**From:** Lindsey Ozbolt  
**Sent:** Wednesday, September 23, 2015 3:13 PM  
**To:** mikej@mdjcontractors.com; ericj@mdjcontractors.com  
**Cc:** 'Shannon Johnson'; Brenda Larsen  
**Subject:** RE: Currier Heights Project Description

**From:** Shannon Johnson [mailto:johnsons@ci.ellensburg.wa.us]  
**Sent:** Wednesday, September 23, 2015 2:31 PM  
**To:** Lindsey Ozbolt; Brenda Larsen  
**Subject:** FW: Currier Heights Project Description

**From:** Joe Seemiller  
**Sent:** Wednesday, September 23, 2015 2:14 PM  
**To:** Shannon Johnson  
**Subject:** RE: Currier Heights Project Description

SHEET CONTENTS
SITE PLAN

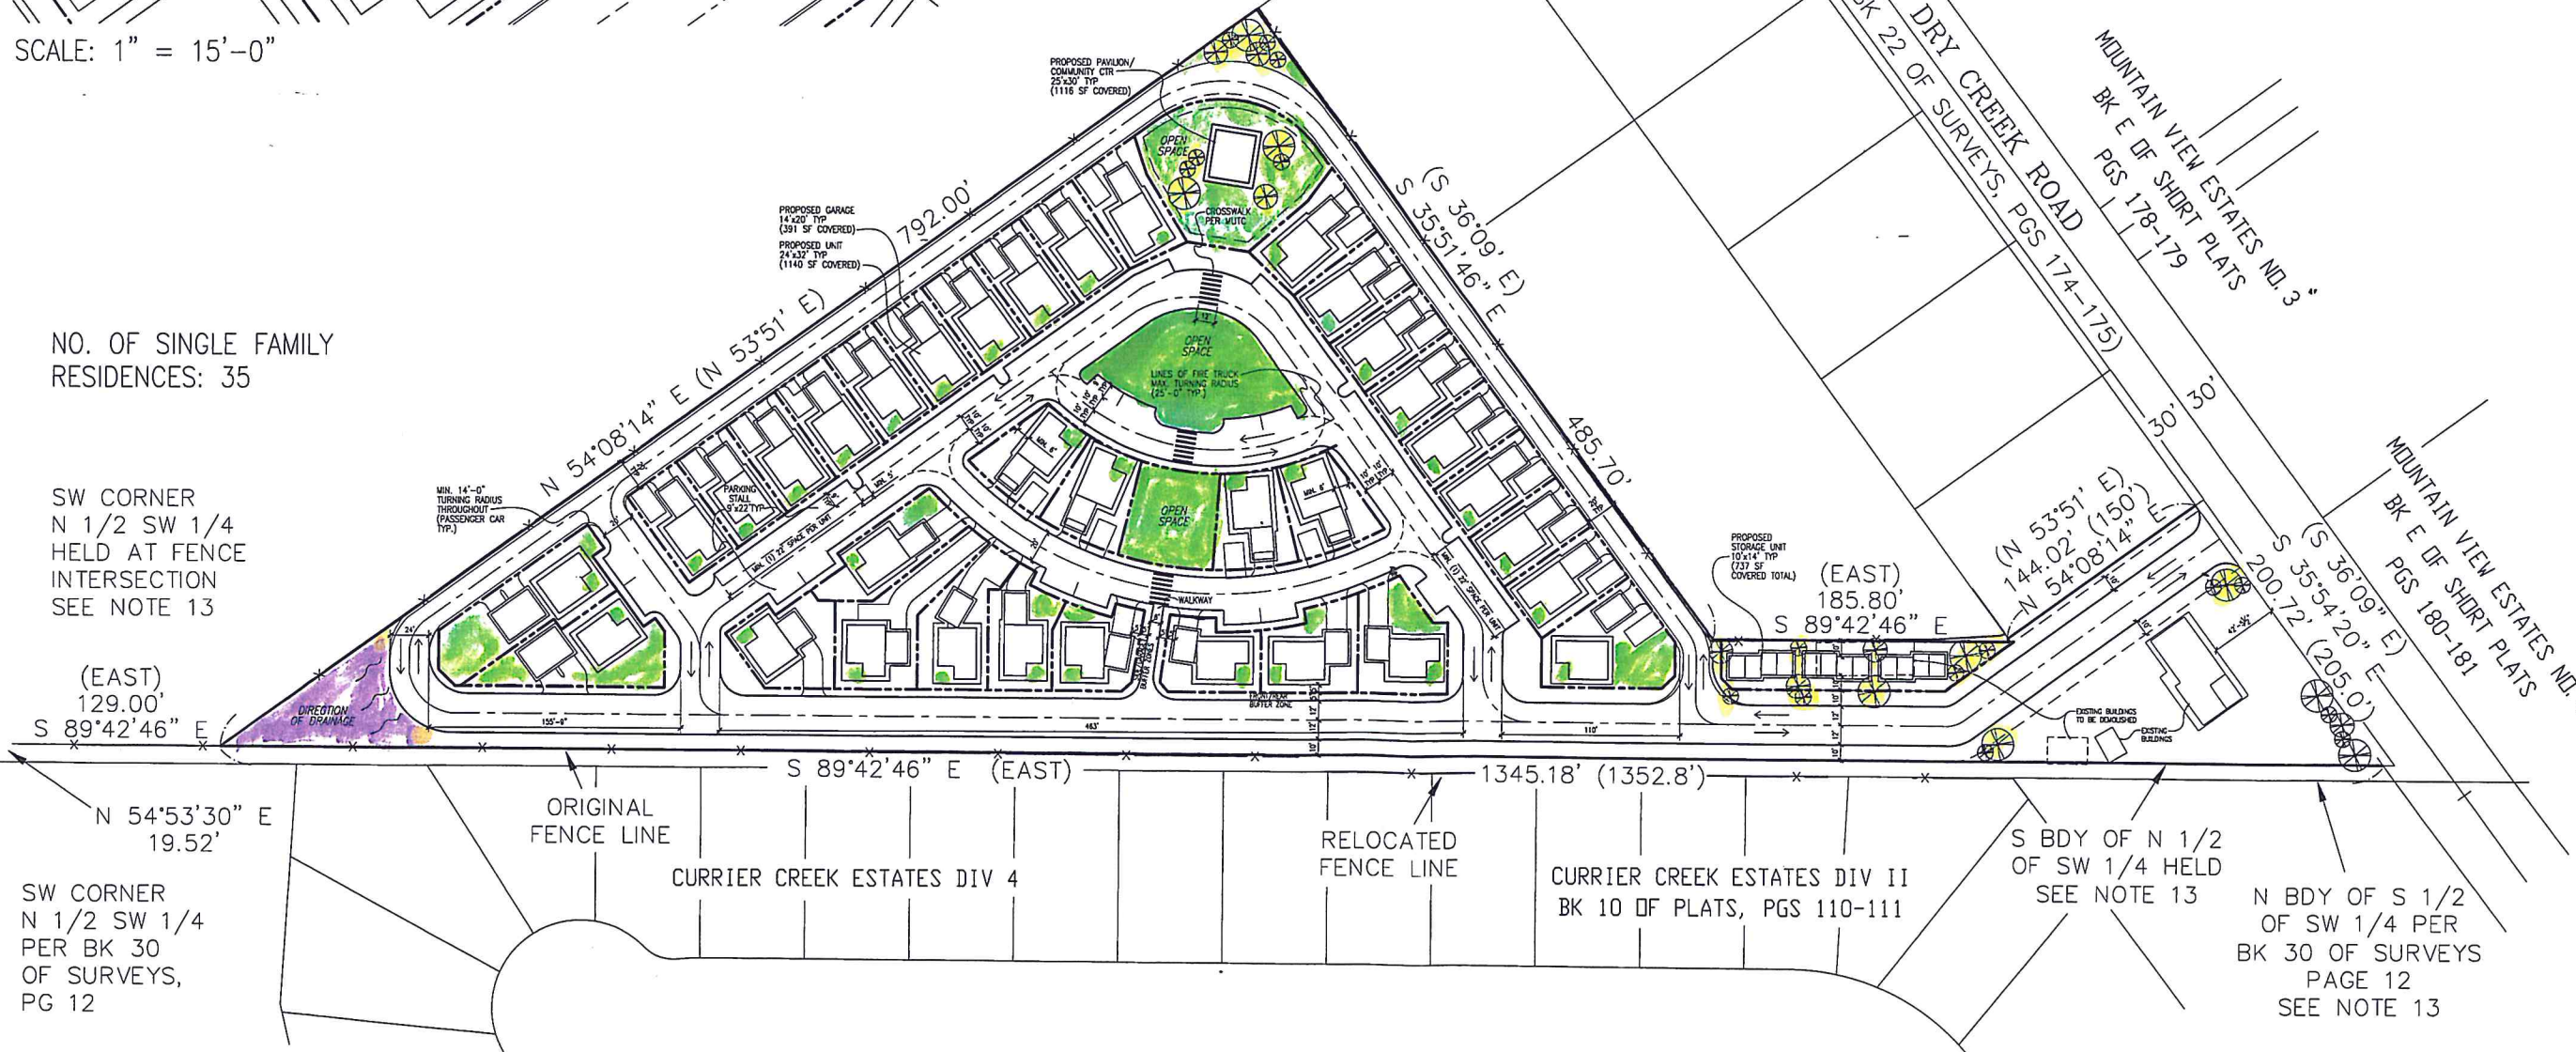
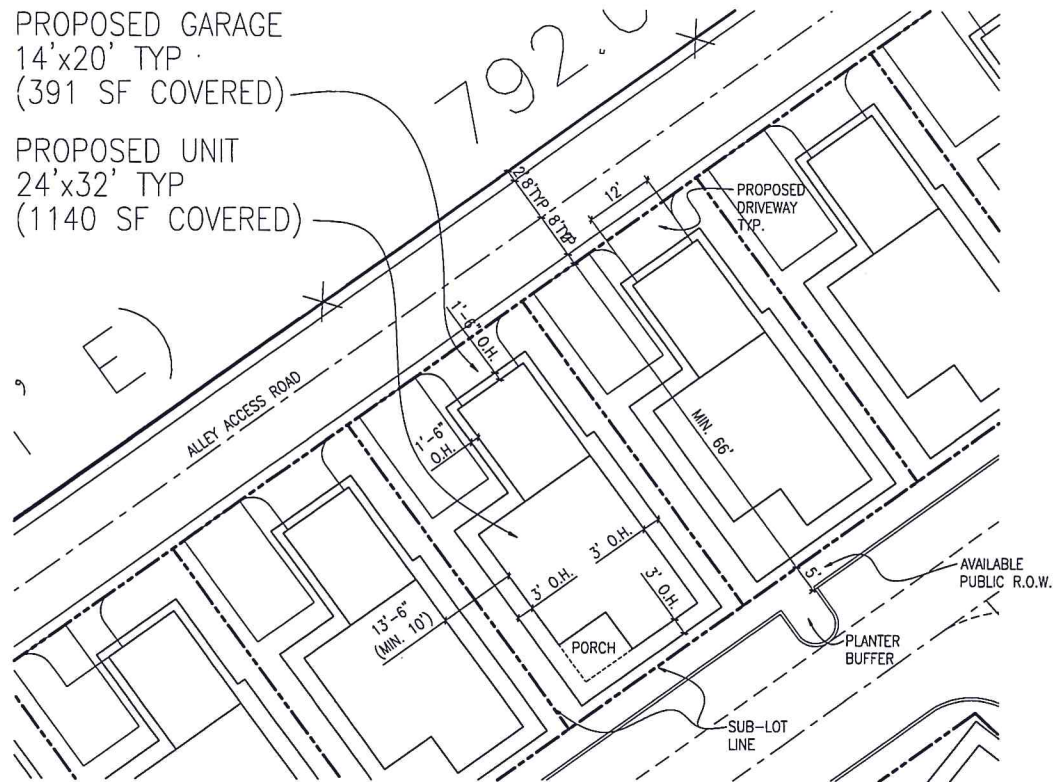
My input would be that they need to provide a second access road or install fire sprinkler in the homes. Thanks.  
Joe S.

I forgot the cul-de-sac must have a minimum diameter of 90 feet and "NO PARKING" signs must be posted.  
Joe S,
